Application number: 2026/91547	
What is the application for?:	Change of use of residential dwelling (Use Class C3) to childrens care home for
Address of the site or building:	28, Sylvan Ridge, Huddersfield, HD2 1ZH
Postcode:	HD2 1ZH

Type of comment: An objection	
Do you wish your comments to be published on the website anonymously?	Yes
Application No: 2026/91547 this document created 1st July 2026 Case Officer: Danielle Cooper Applicant: S Yousaf List of Planning Objections and Representations to the proposed change of use to number 28 Sylvan Ridge HD2 1ZH from its current residential use (class C3) to a residential Care Home for up to two children (class C2) and external alterations to form additional parking area. 1) I object because the applicant has not demonstrated that 28 Sylvan Ridge is a safe and suitable location for vulnerable children. The recent Inspector's dismissal of the children's-home appeal at 2 Robin Hood Road (also located on our housing estate) identified serious deficiencies in site-specific safeguarding evidence. I propose the applicant provide an Impact Risk Assessment on the local crime risks, procedures to be put in place to cover unauthorised absence and

BLOCK PLAN

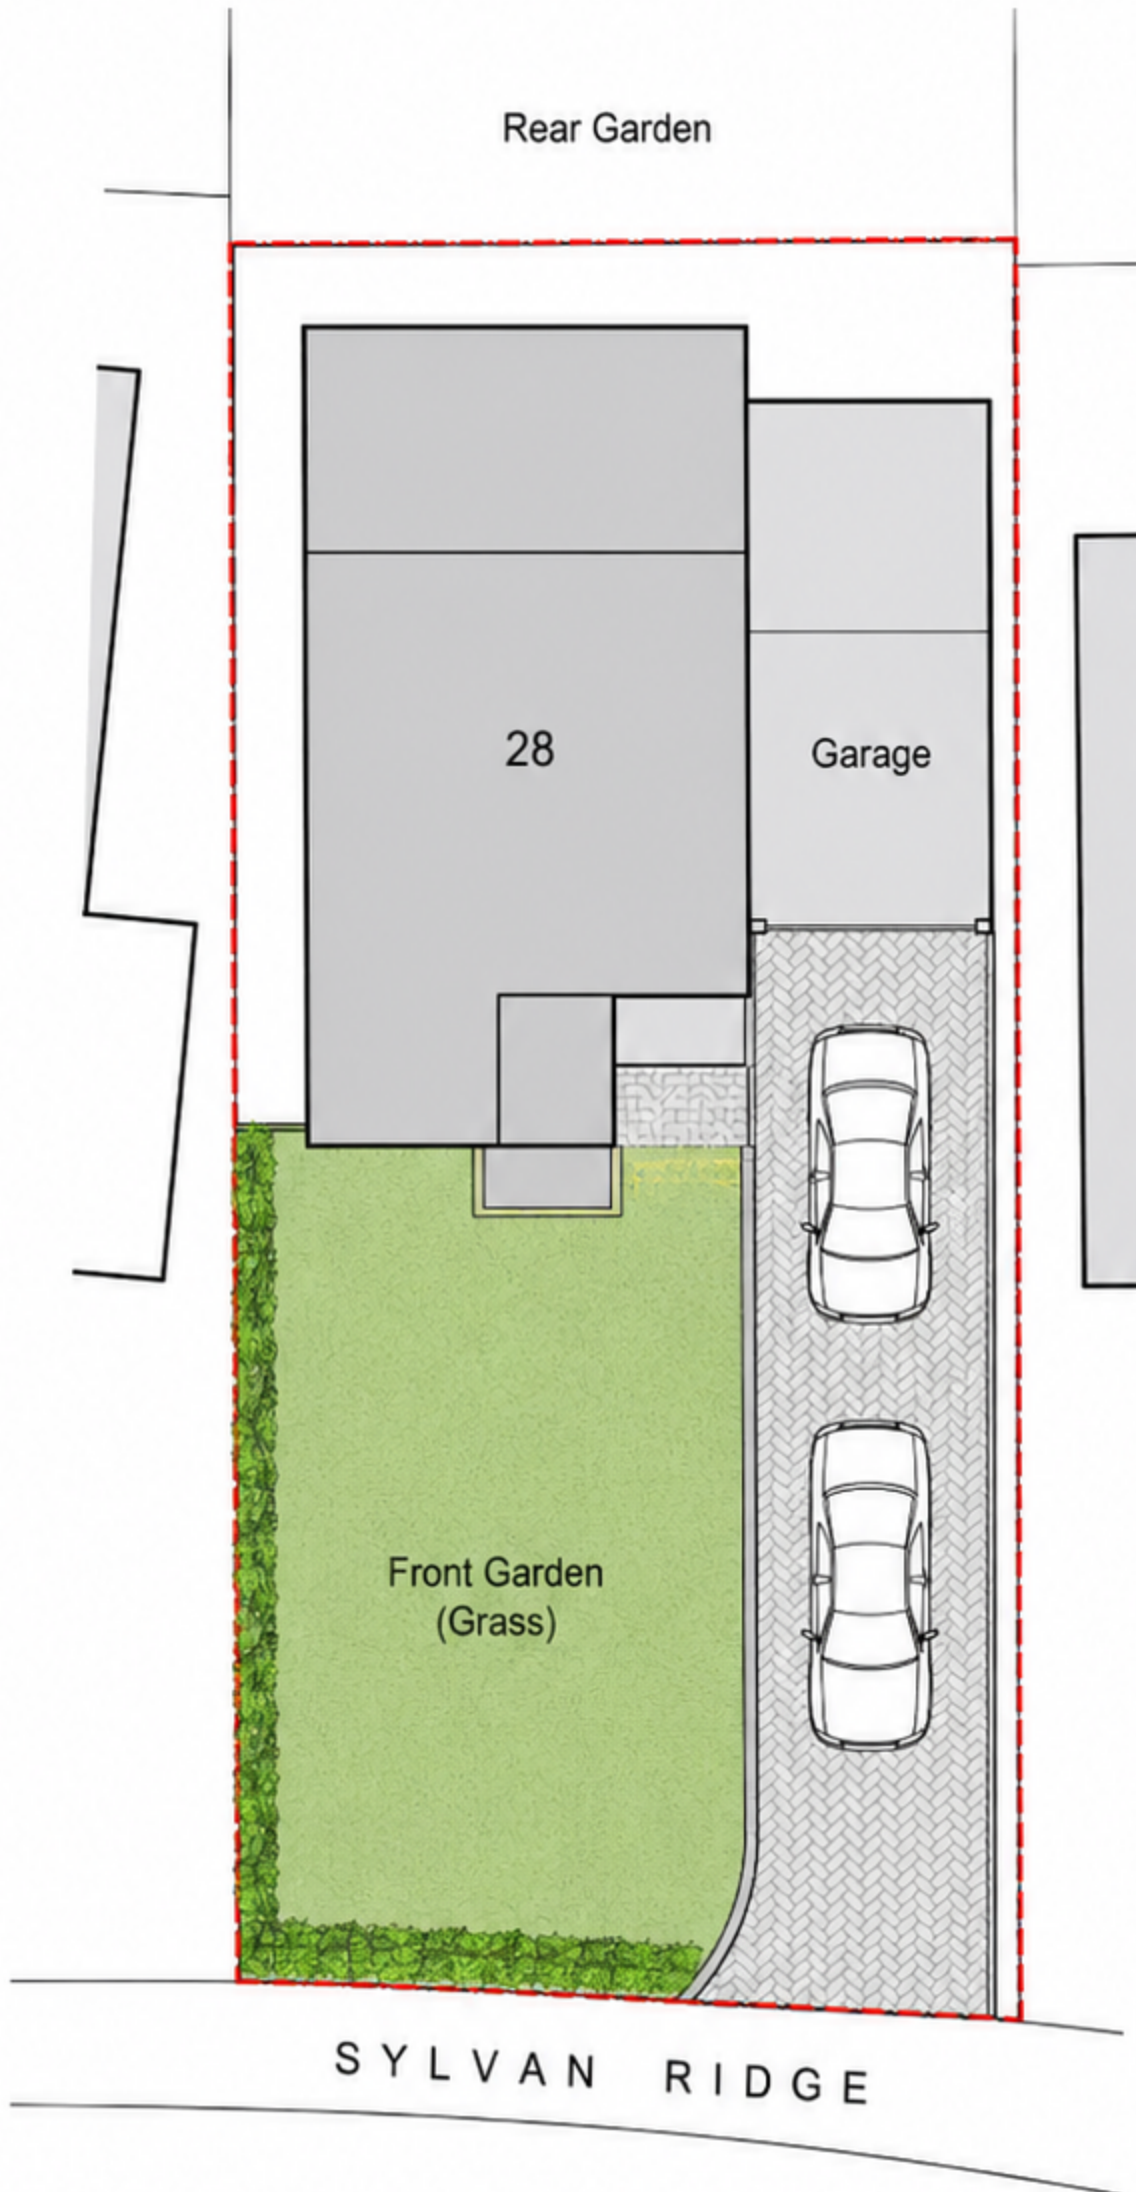
by the Applicant. The only way to increase on-street parking is to hard-surface the existing grass lawn to the left of the drive. The Applicant has applied for separate planning permission to do this. The Applicant's block plan is very misleading in that the lawn is shown much bigger than it is in reality. The lawn is drawn at double the width of the adjacent drive implying there is plenty room to create two more car parking spaces. Site measurements establish the drive is 2.80 metres wide but the lawn next to it is only 2.30 metres wide. If the original planners determined a width of 2.80 metres was necessary to allow the unrestricted opening of the car doors on both sides of the car, then is 2.30 metres too narrow a width? The Applicant should provide a fully dimensioned drawn to scale block plan to illustrate the actual size width of the lawn in contrast to the existing width of the drive. Further details of the conversion of the lawn to a car park should be submitted to planning. These include the type of surface material to be used, is it permeable, are extra water run-off drains to be installed, the amount of landscaping that would be removed or retained specifically the mature hedge forming the left-hand boundary of the lawn.
